Your ref: PAE-89057722
Our ref: DOC25/617149-33

Re: Huntlee New Town - Stage 2 (SSD-70748466) – Response to Submissions

Attachment 1 - CPHR Comments on Huntlee New Town - Stage 2 (SSD-70748466) – Response to Submissions

Huntlee Stage 2
 (NL220566)

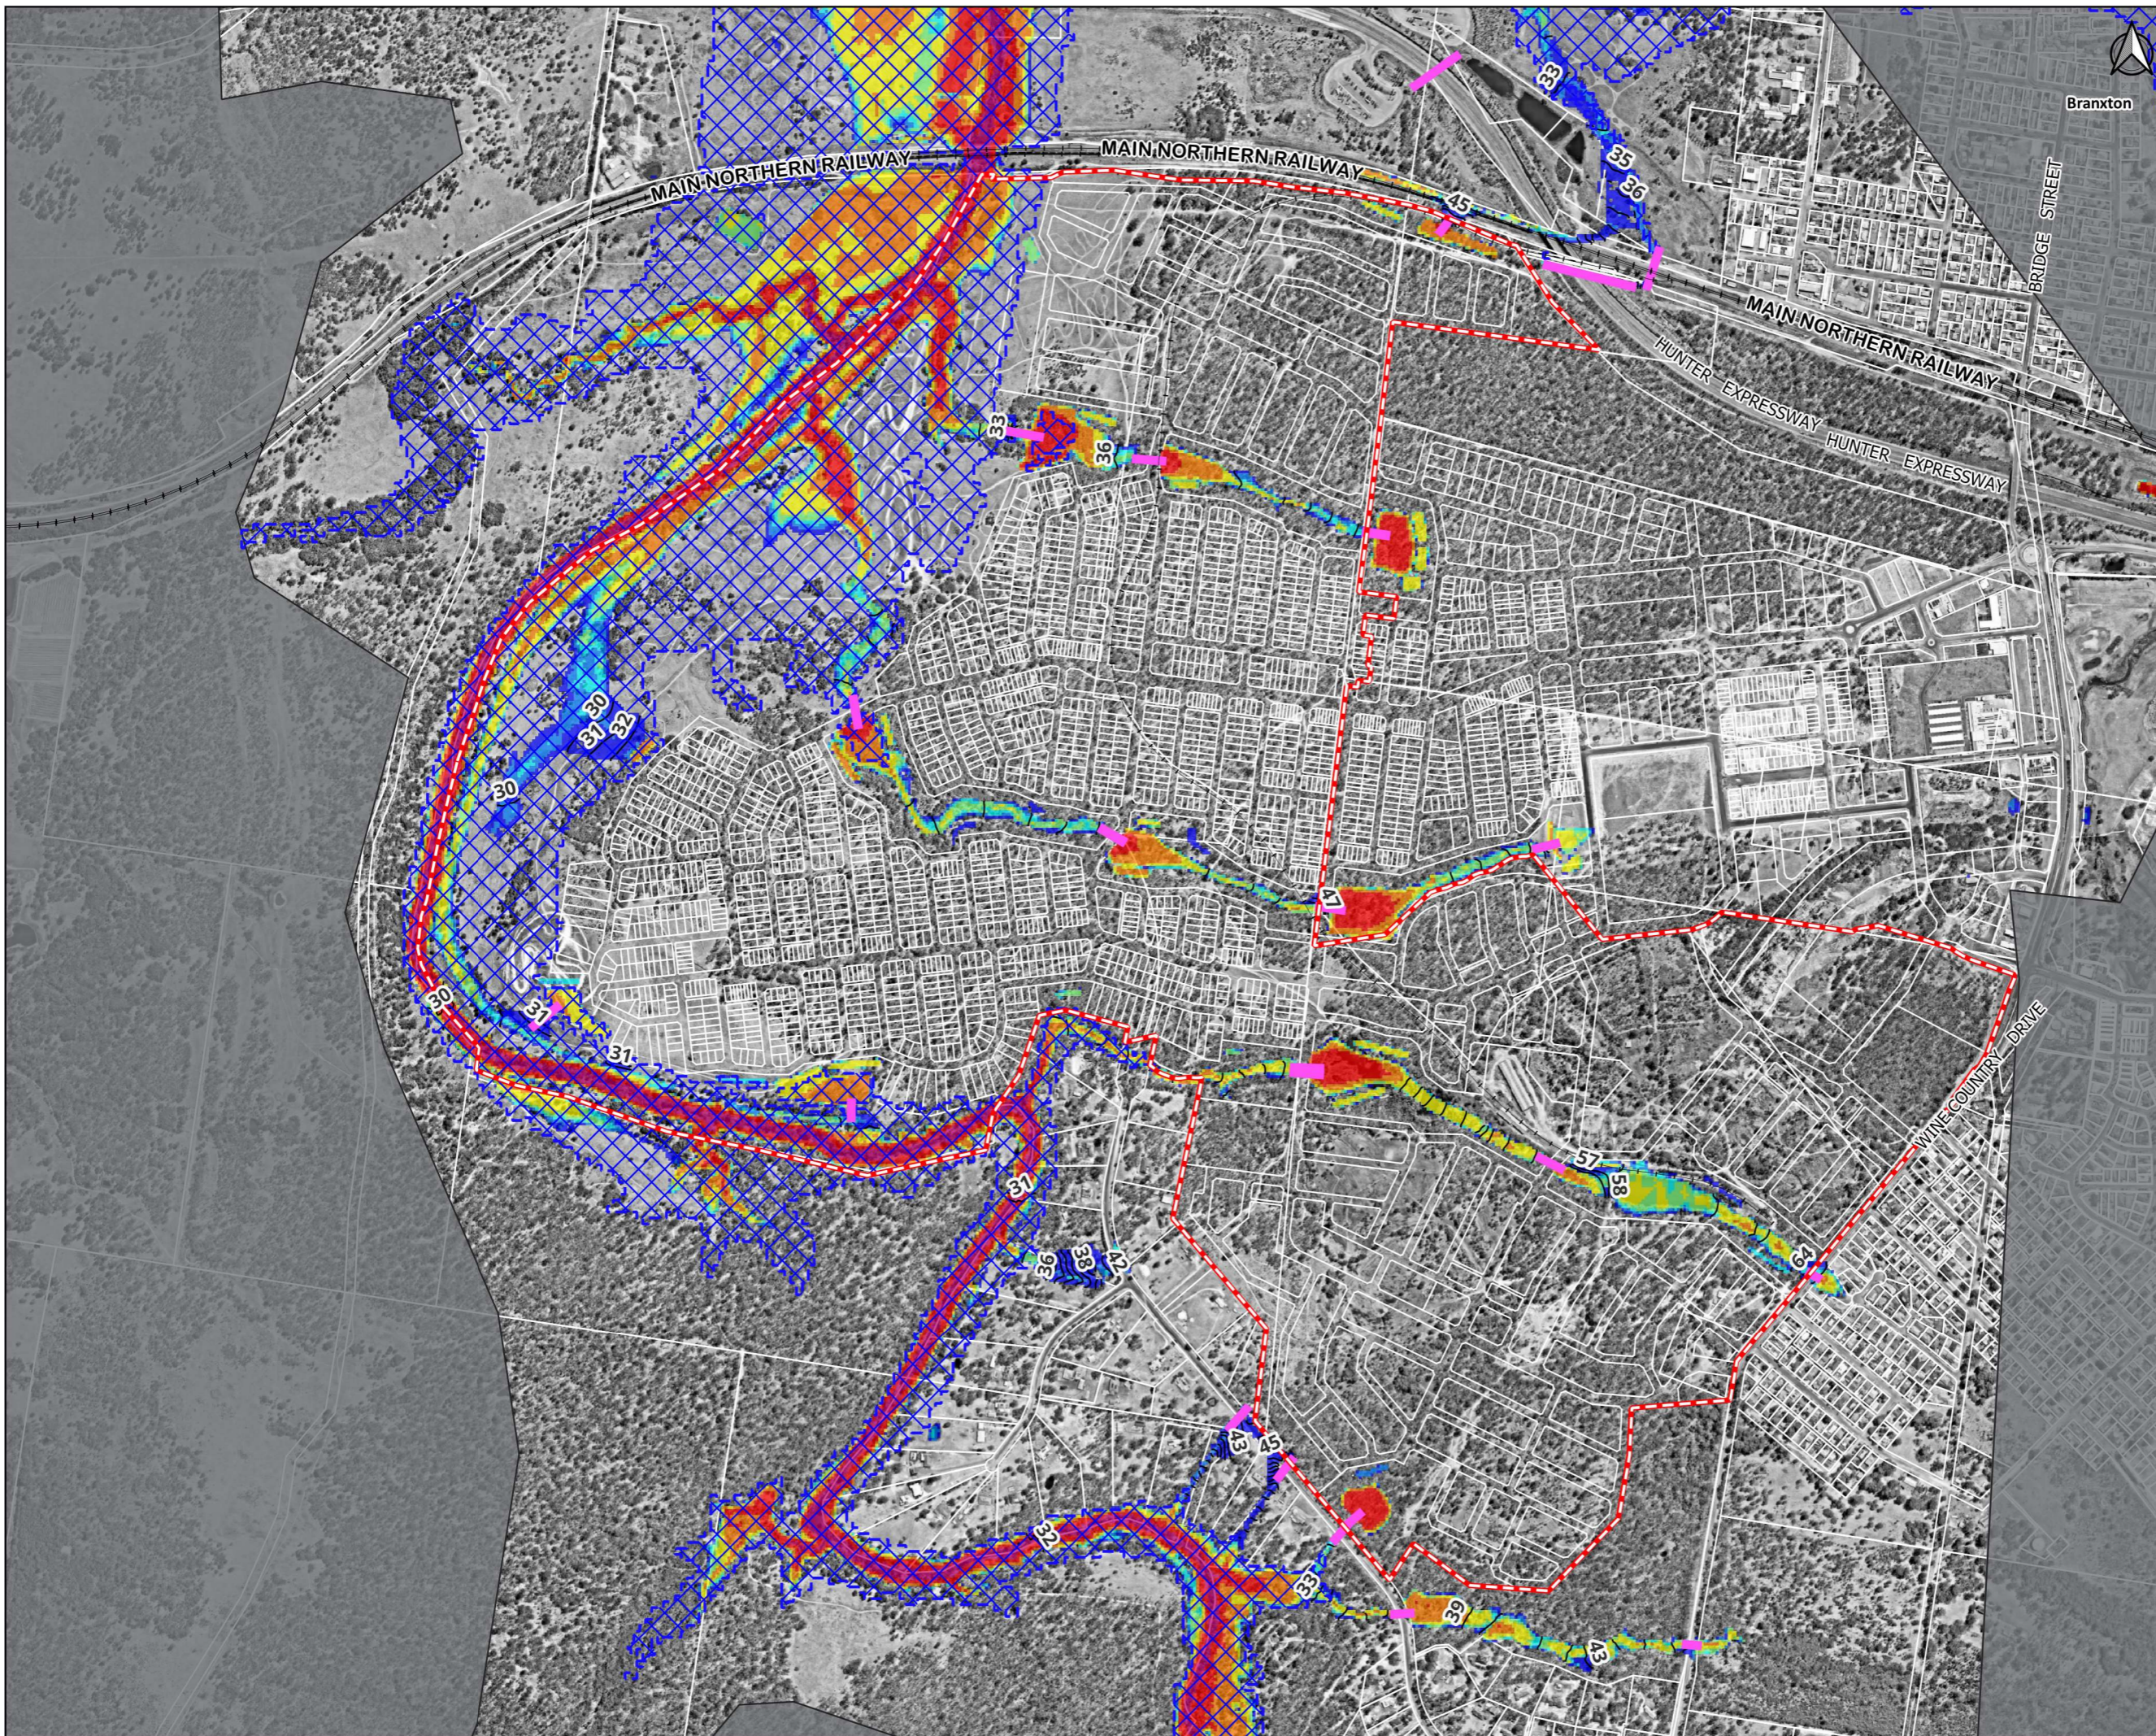
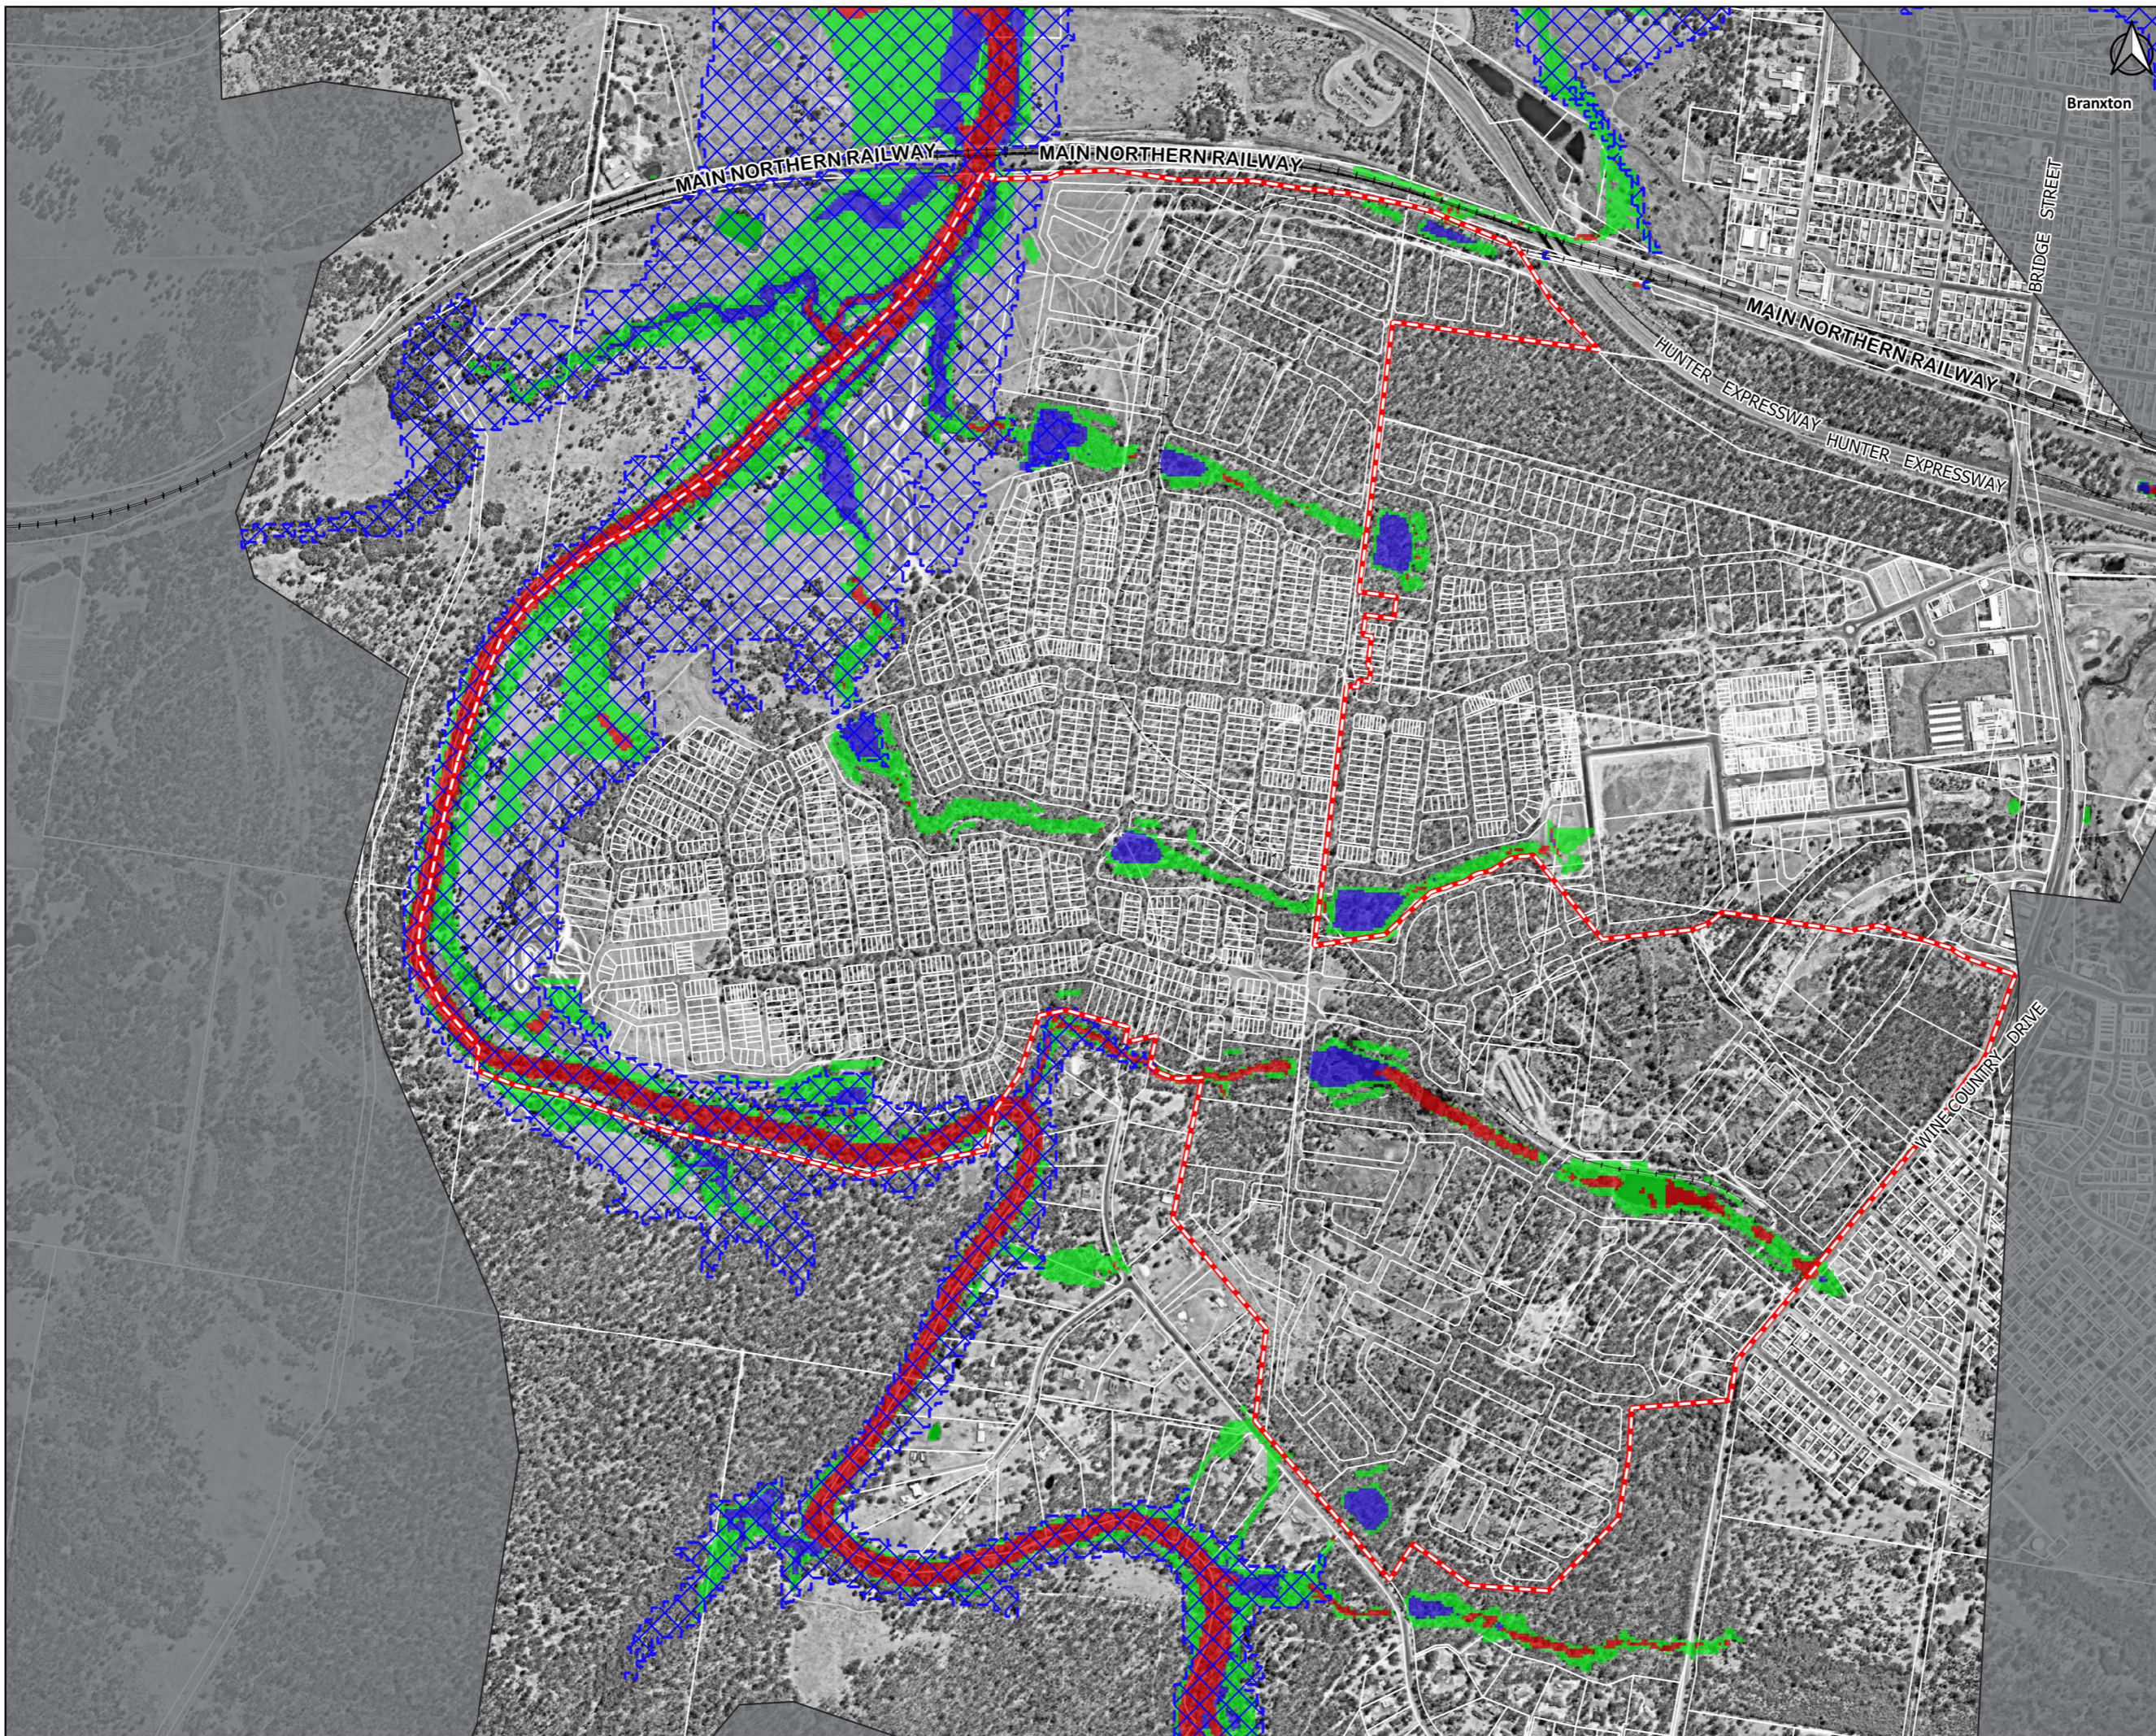
CPHR Issue 15	The sensitivity of structure blockage factors should be assessed for developed case flood conditions.
	Note this is an old issue that has not been addressed. Structure blockage factors, determined in accordance with Australian Rainfall and Runoff Guidelines 2019, have been adopted for modelling of design flood conditions for the developed case. Consideration of higher blockage factors should be undertaken as a sensitivity assessment for the range of design events, to ensure freeboard at road crossings is appropriate. Additionally, higher blockage factors at key drainage infrastructure may increase flows across lots and roadways during larger local catchment flood events (1% AEP or rarer). The impact on flood emergency management, including extent of possible inundation, warning time and road trafficability needs to be understood. In addition to increase in peak flood levels along existing flow paths, Figure 91 of the EIS must also indicate the increased inundation extent due to blockage. Impact maps should be updated to include “was dry, now wet” extents to determine if flood impacts are expected to extend to lots or roadways.

Recommendation	Blockage of drainage structures should be considered as a sensitivity for developed case flood conditions, including the impact on flood emergency management. Flood impact maps should be updated to include “was dry, now wet” extents.
Recommended Conditions of Approval	TBA
